William Parker
554 McNeill Mill Rd.
Broadway, NC 27505
RE: Parker's Pizza

A plan review was received by this office concerning the construction of the above referenced facility. The plans have been reviewed and are not approved at this time. Please address the following items and/or provide additional information for reconsideration:

Cindy Pierce, REHS
Environmental Health Section
Harnett County Health Department

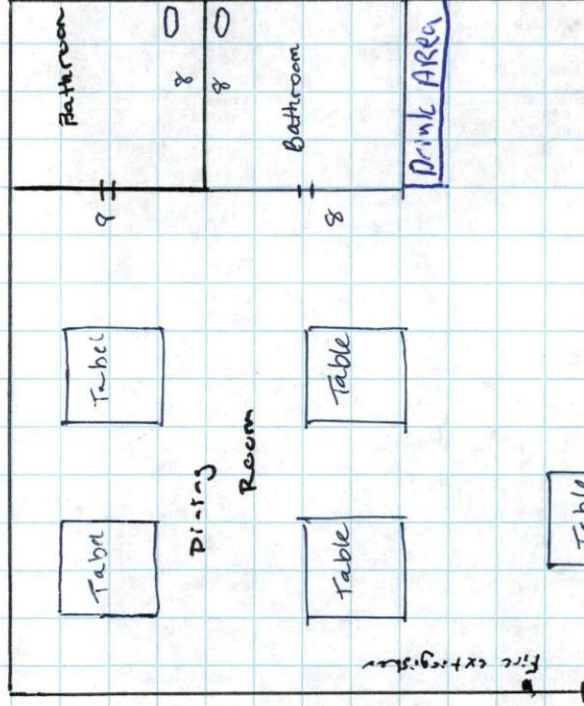
- Clarify whether the item labeled the "prep side" is in fact the prep sink.
- Please provide a full detailed menu including options.
- Please provide a full set of food process sheets. Food process sheets were not complete for each food type or menu product. Indicate all aspects of food handling procedures as requested.

- The number of tables and shelves listed on the equipment list does not match the kitchen layout.
